MODIFICATION REQUEST:

132-138 Killeaton Street, St Ives

**MP10_0057 MOD 6 – Modification to add
Pergolas to Blocks A, B & D**

Director General's
Environmental Assessment Report
Section 75W of the *Environmental Planning and
Assessment Act 1979*

BLOCK B ELEVATIONS

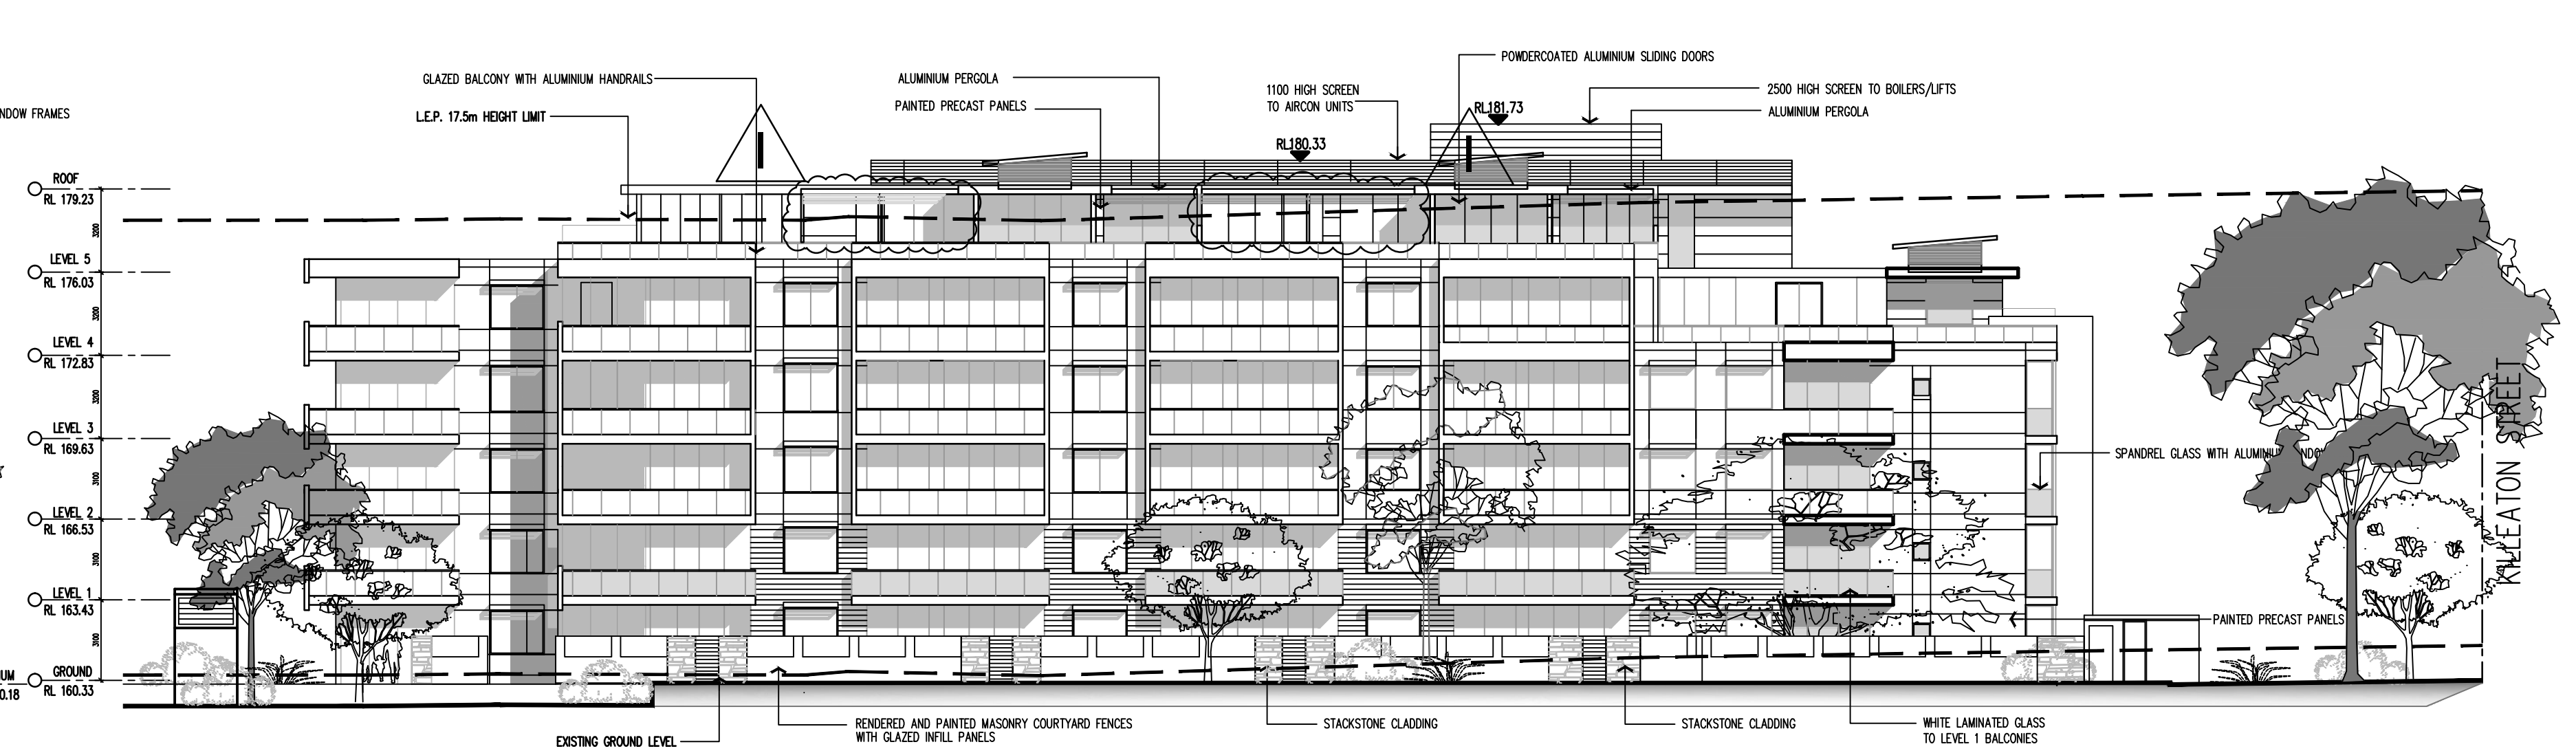
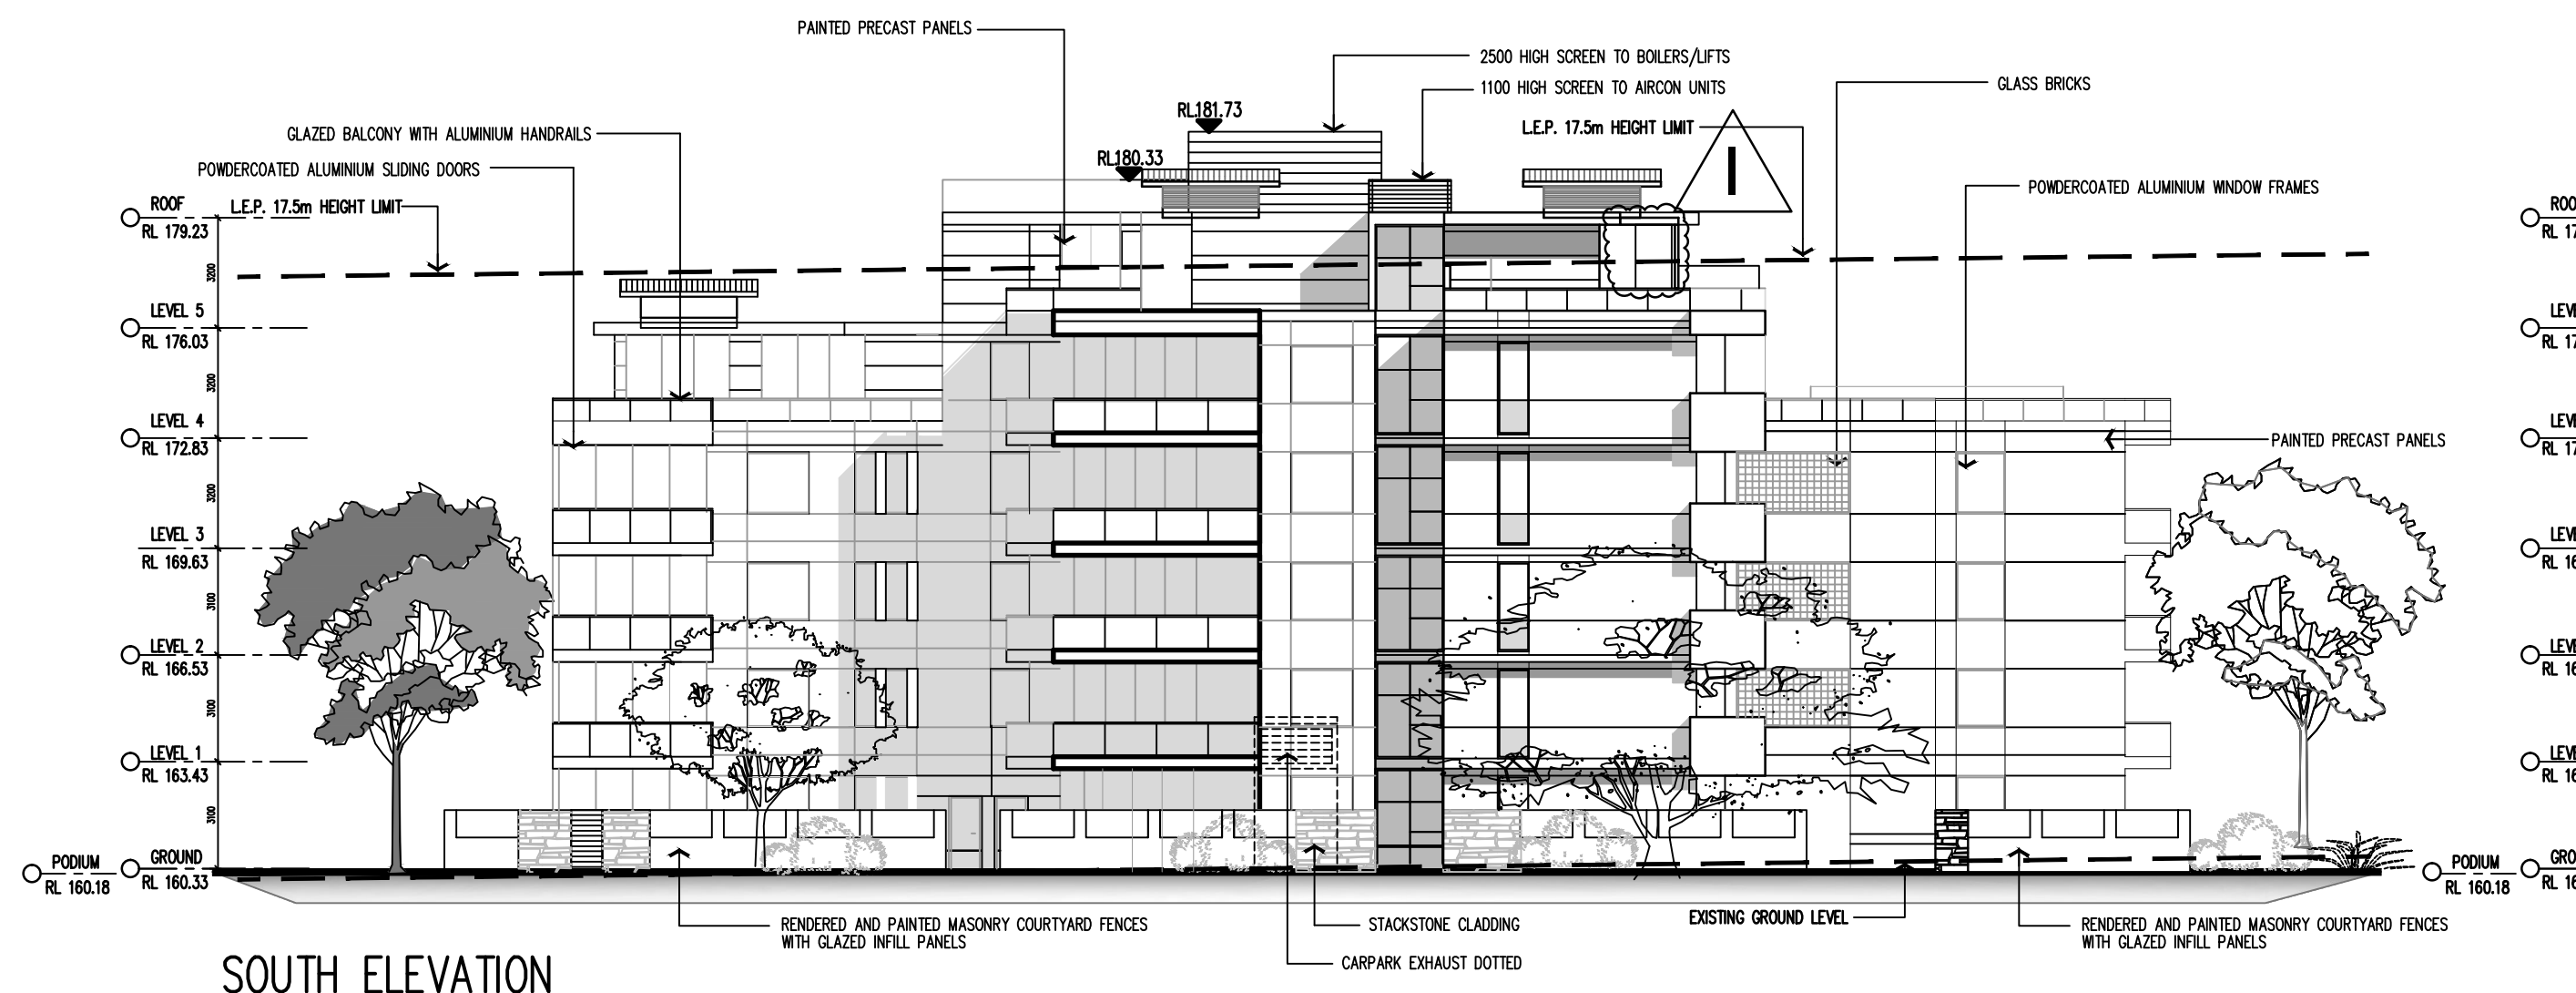
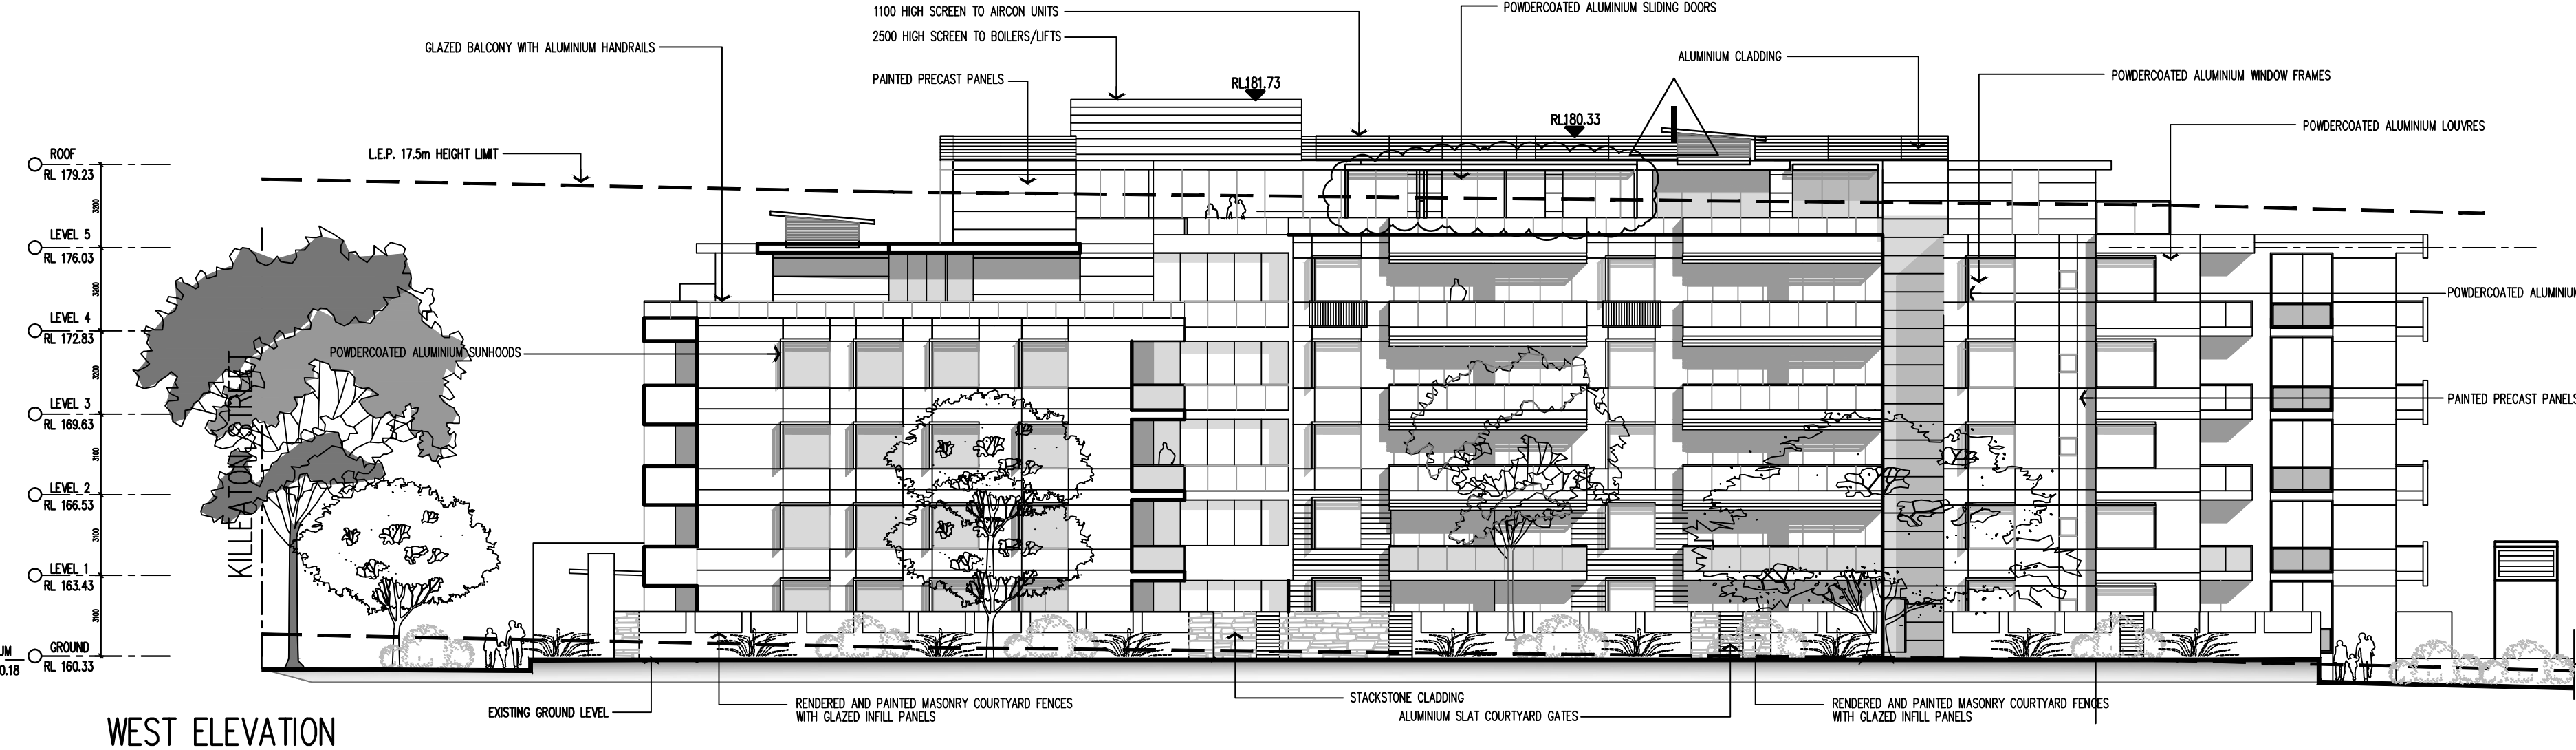
- Ku-ring-gai Local Environmental Plan No. 194 requires the top storey to be 60% of the floor below. Therefore, the top storey and associated ancillary structures are to be setback from the external edge of the building to recess the top storey and reduce the massing of the building at the uppermost level;
- pergola structures to the edge of the buildings are not supported as recessing of the top storey loses its design intent. It is recommended that pergola structures be setback, preferably 1.5m-2m where possible; and
- pergola structures must be of light weight material finish and open style to ensure the bulk, scale and design of the top storey remains relatively unchanged.

Ku-ring-gai Council (Council) did not support pergola structures being constructed to the edge of the building line as recessing of the top storey loses the building's design intent. Council advised that the top storey and associated ancillary structures such as pergolas be setback from the external edge of the building to recess the top storey and reduce the massing of the building at the uppermost level. Council recommended that pergola structures be setback, preferably 1.5m-2m.

- all pergola structures will be setback a minimum of 2 metres from the approved building line as shown in the amended plans.

The proponent responded to the Council's submission by submitting amended plans which shows all proposed pergolas being setback a minimum of 2 metres from the approved building line. The proponent has also acknowledged that the pergolas will be constructed of lightweight materials that will allow for visual transparency.
